Item No. **Report of the Head of Planning, Sport and Green Spaces**

Address 277 KINGSHILL AVENUE HAYES

Development: Part two storey, part single storey rear/side extension

LBH Ref Nos: **7175/APP/2014/4179**

DRAWING NO: KINGSHILL/04

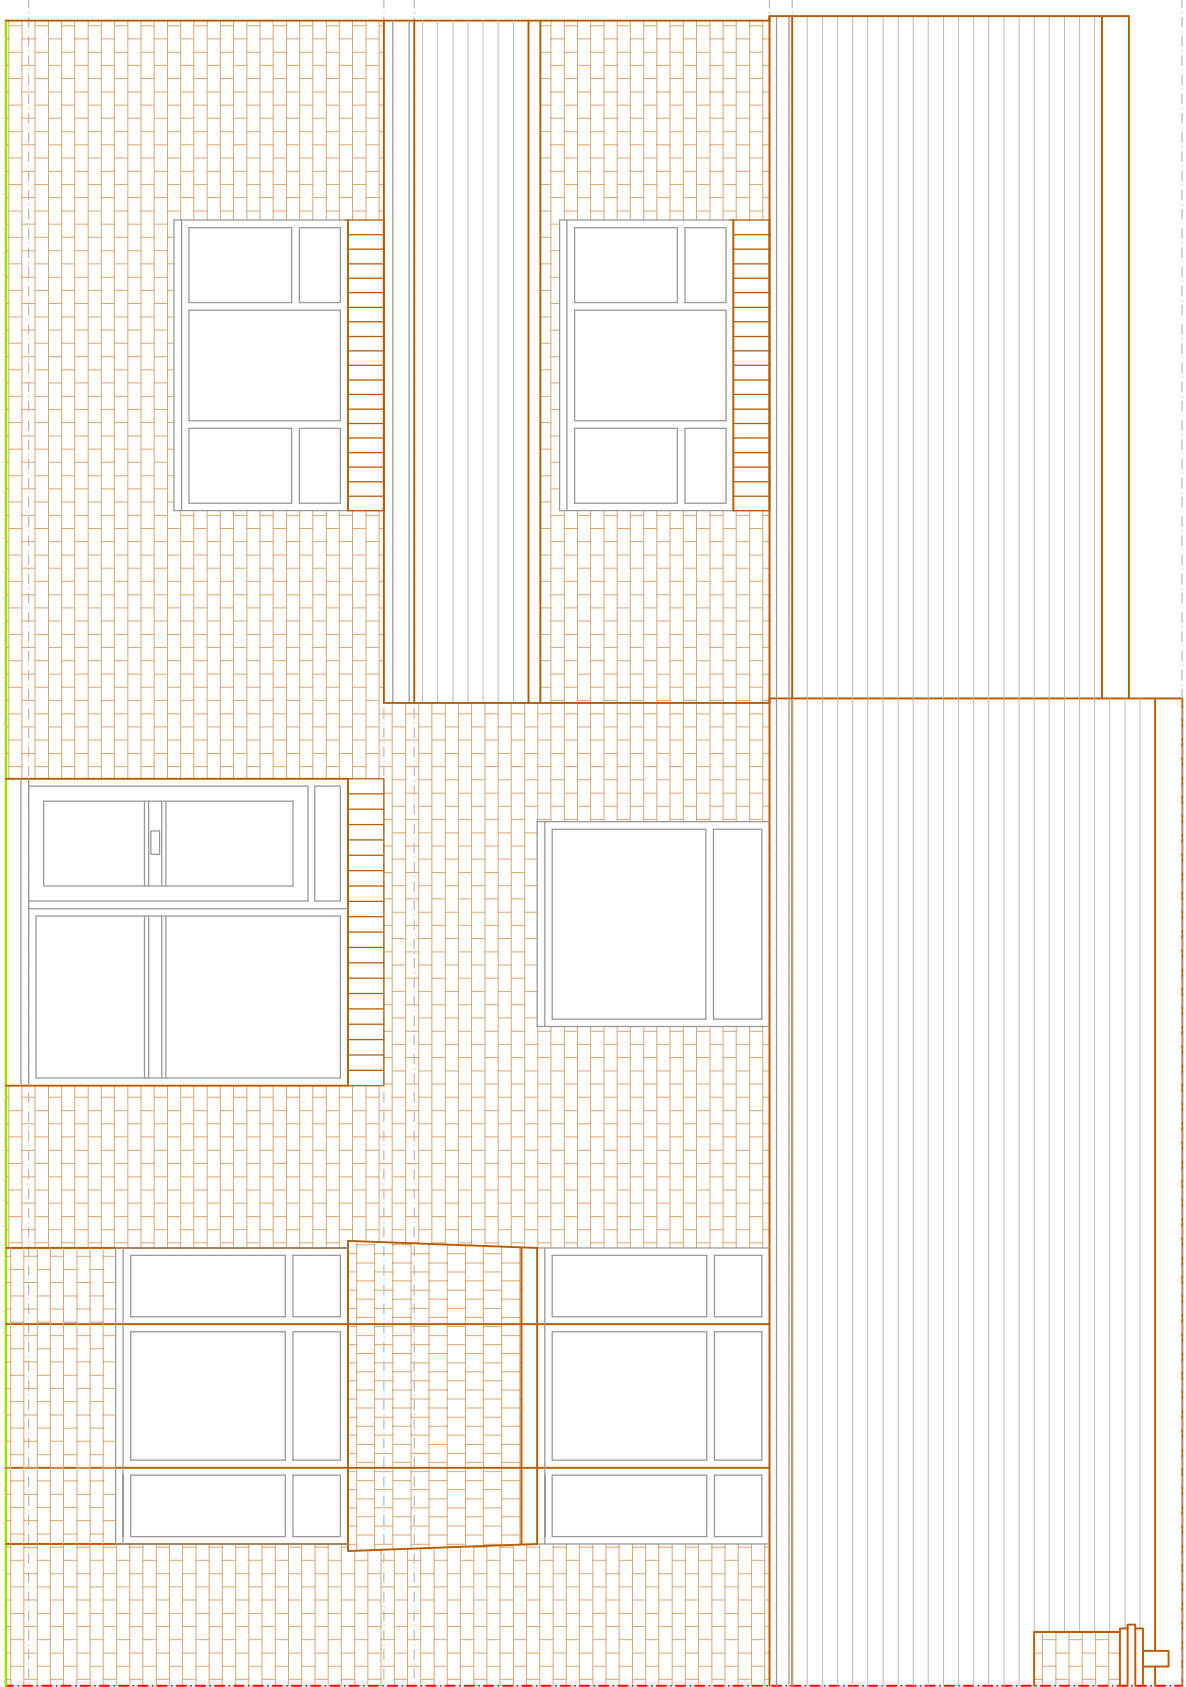
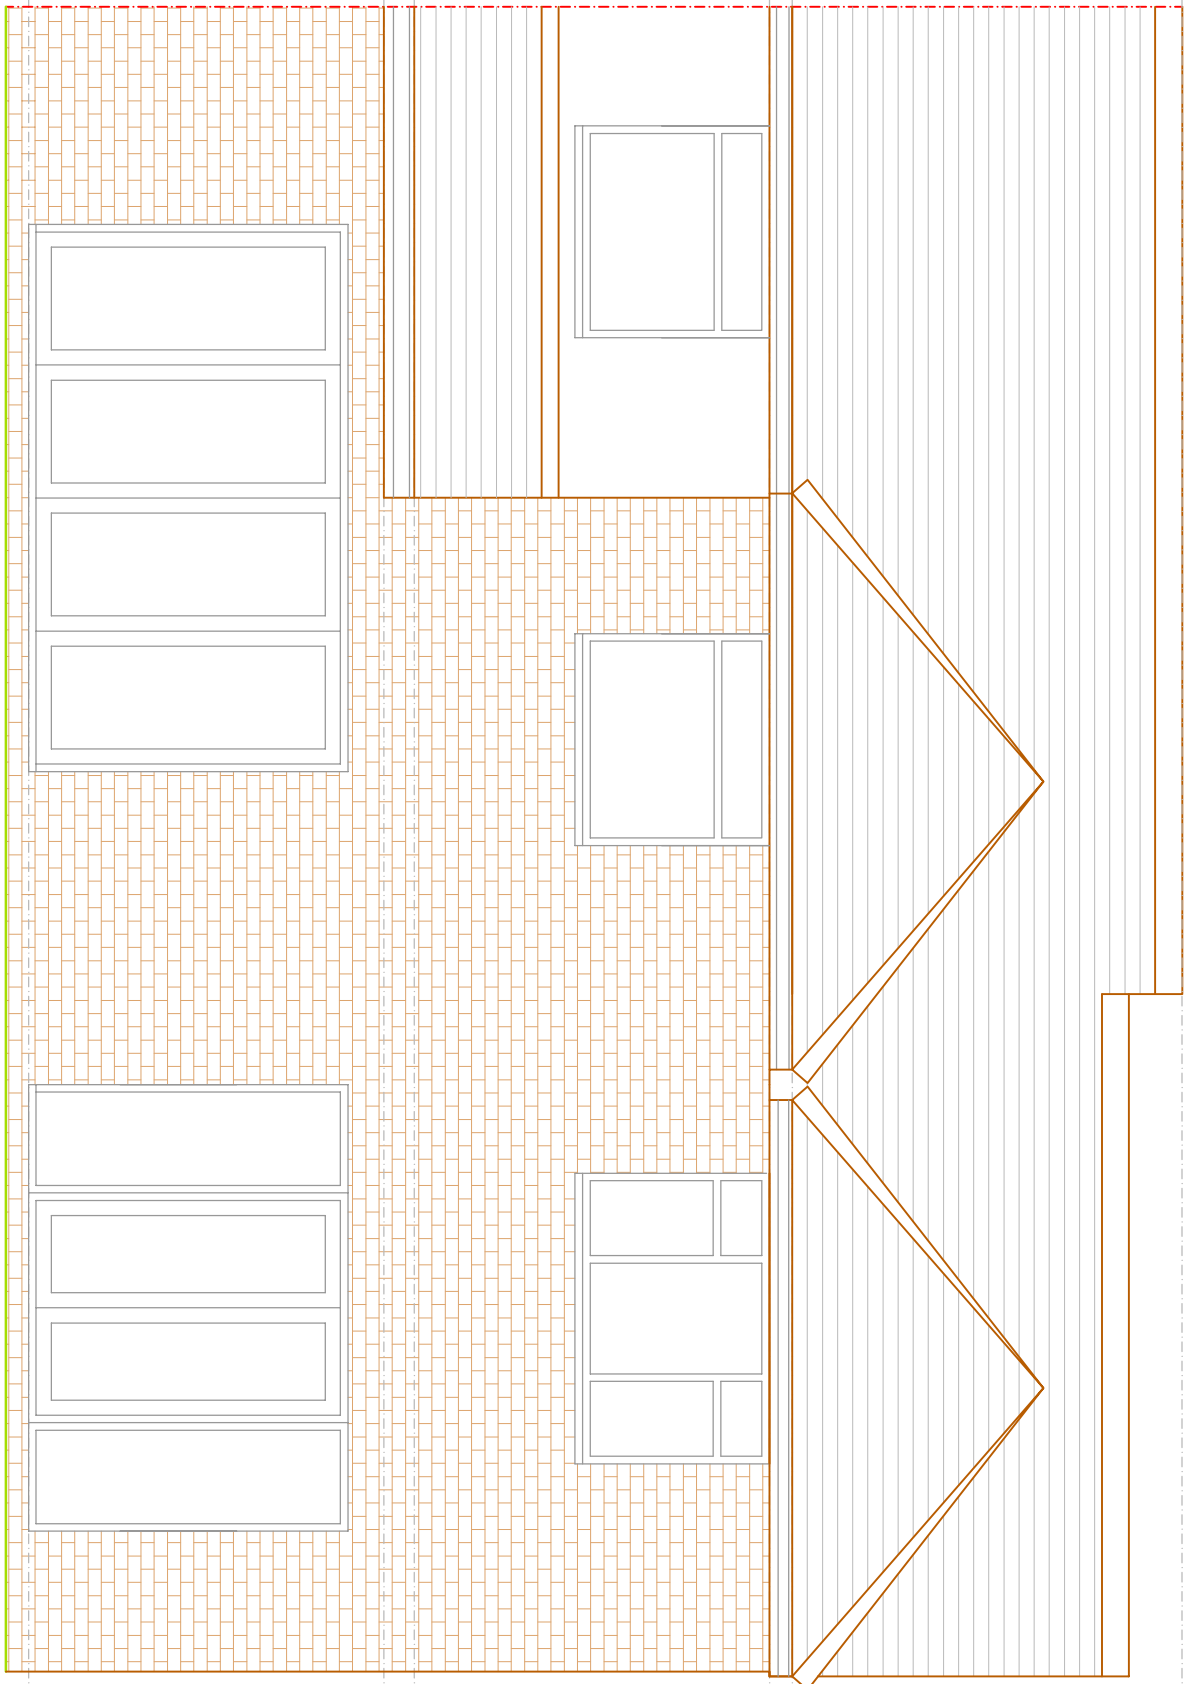
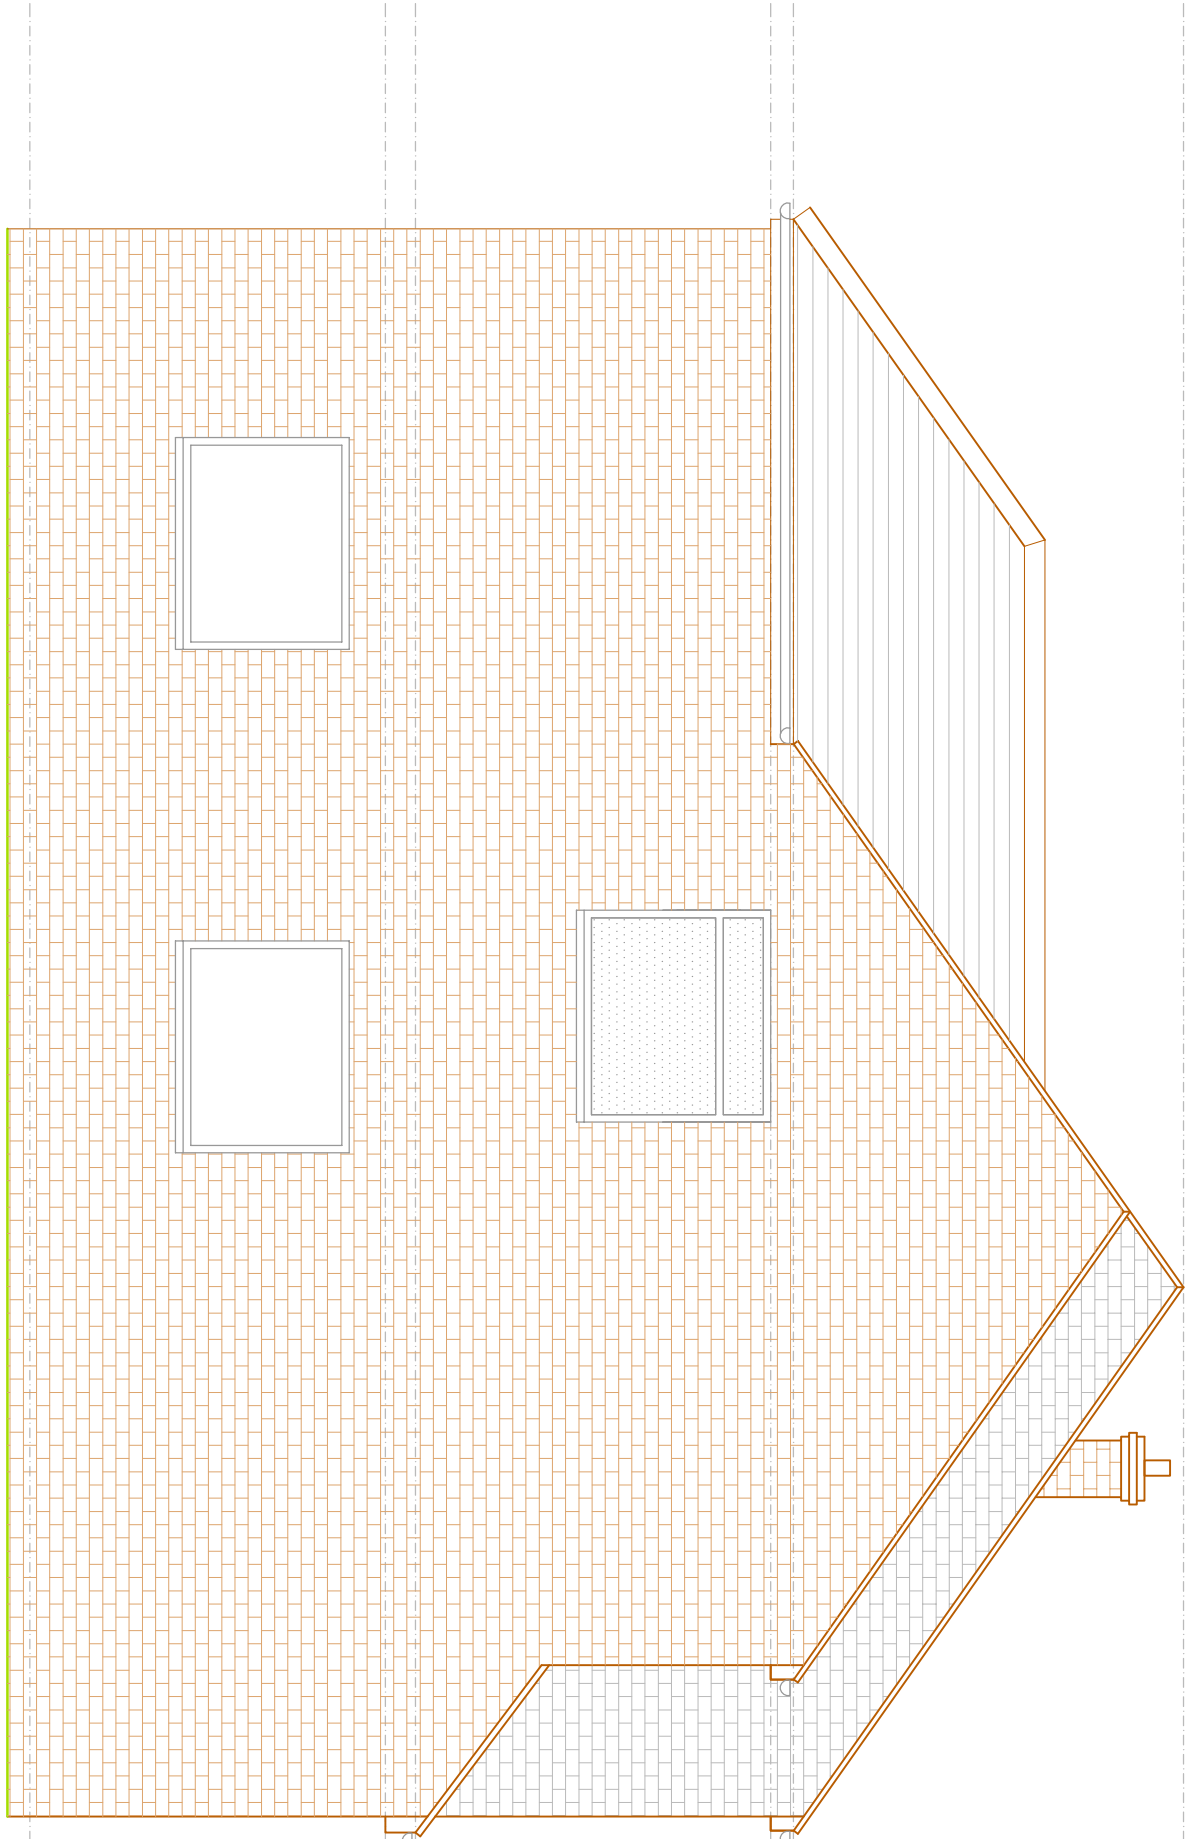
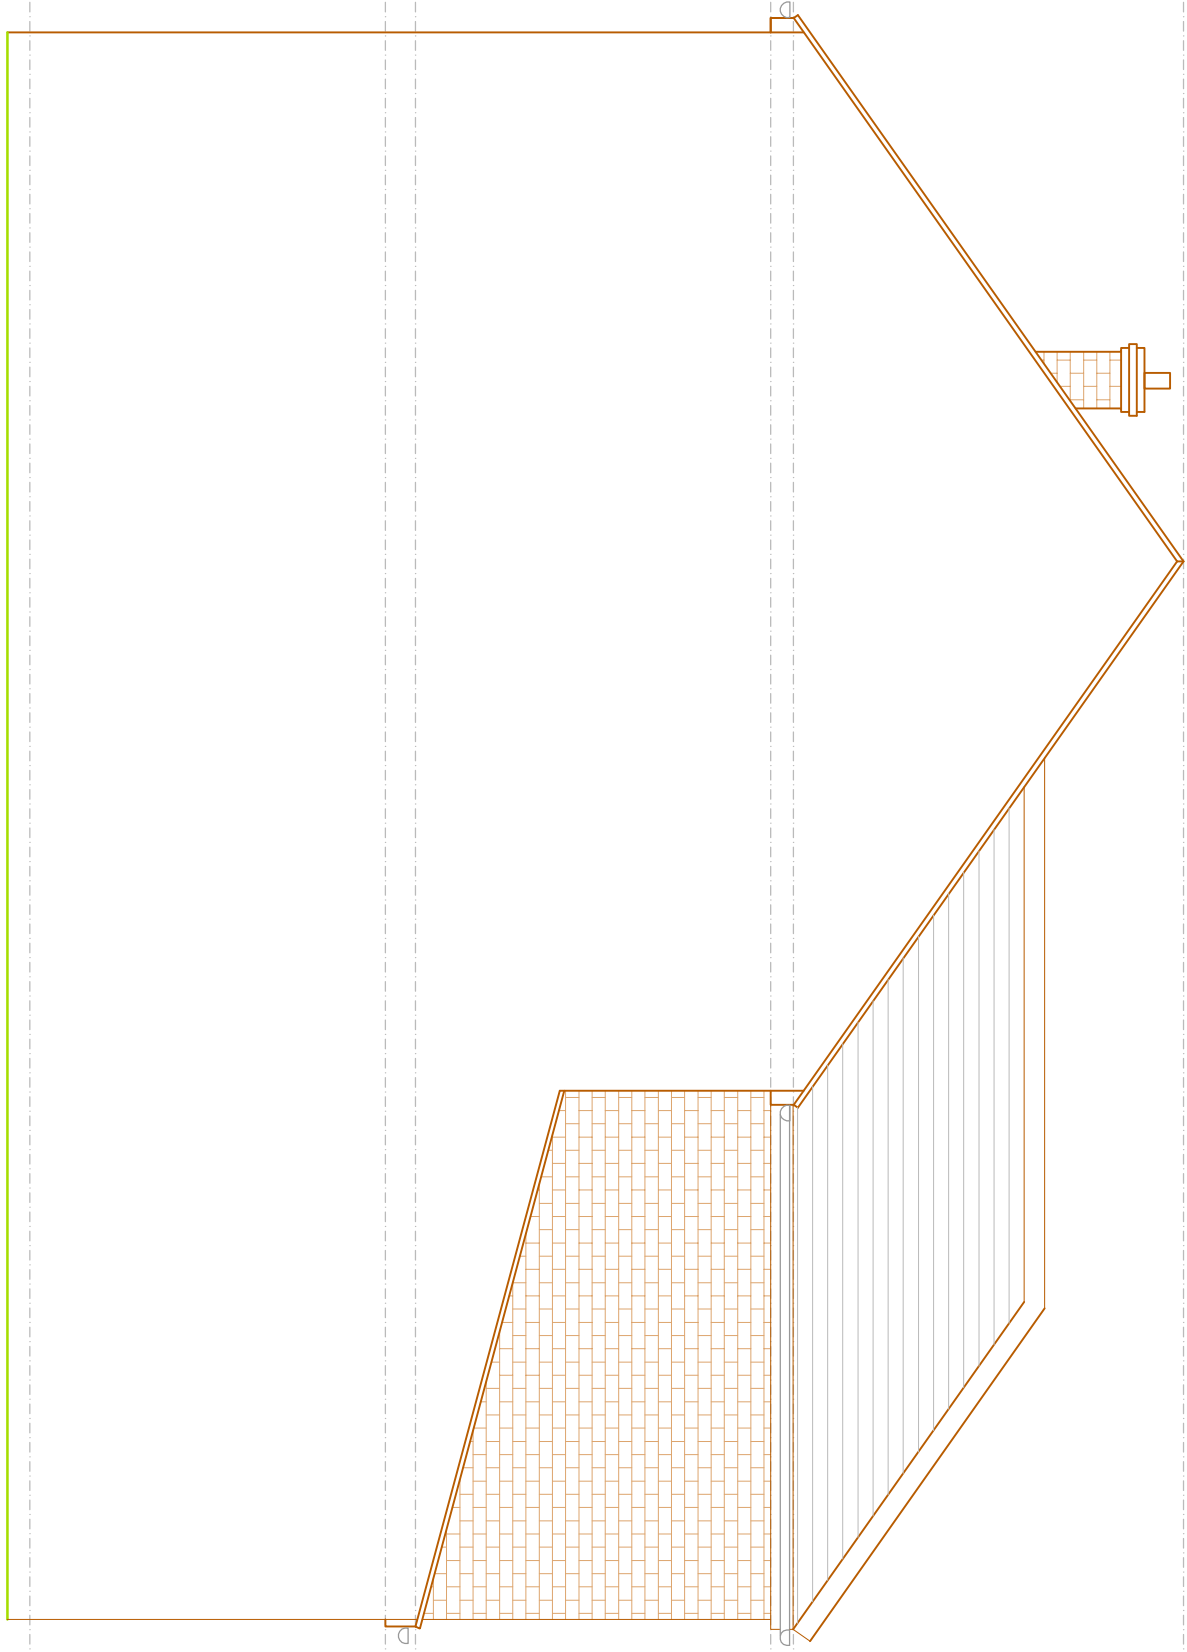
The garden area to the side of the existing dwelling makes an important contribution to the spacious character of the area. The proposed extension will largely fill this area with a gap of just 1.5m being retained between the flank wall and Dale Drive. Paragraph 5.3 of the HDAS refers to two storey side extensions on corner plots and states that the return building line should not be breached and the extension should maintain the openness of the area. In this case, the return building line would be breached. It is considered that the proposed two storey side/rear extension conflicts with this advice and would detract from the spacious character and appearance of the site within the street scene. As such the application is unacceptable in this respect. Furthermore, due to the excessive width of the proposed two storey side/rear extension, which would necessitate a double hipped roof to the rear, the proposal would fail to appear as a subordinate addition to the host dwelling. This is particularly apparent when the width of the original dwelling (some 6.53m) is considered against the width of the proposed two storey side/rear extension (some 7.71m). It is considered that the proposed extension would dominate the original dwelling and would fail to respect its architectural integrity. The SPD also requires two storey side extensions to semi-detached properties to be set back 1m from the front main wall, at all levels. The proposed extension is in line with the front main wall at ground floor level, again resulting in an extension which would not be subordinate to the main dwelling.

The proposal, by reason of its siting, scale, bulk, excessive width and design, would fail to appear as subordinate additions to the detriment of the architectural composition and design of the original and adjoining dwellings in this visually prominent position. The proposal would also be detrimental to the visual amenities of the street scene and the character and appearance of the wider area and is therefore, contrary to Policy BE1 of the Hillingdon Local Plan: Part One - Strategic Policies (November 2012), Policies BE13, BE15 and BE19 of the Hillingdon Local Plan: Part 2 - Unitary Development Plan Saved Policies (November 2012) and the adopted Supplementary Planning Document HDAS: Residential Extensions.
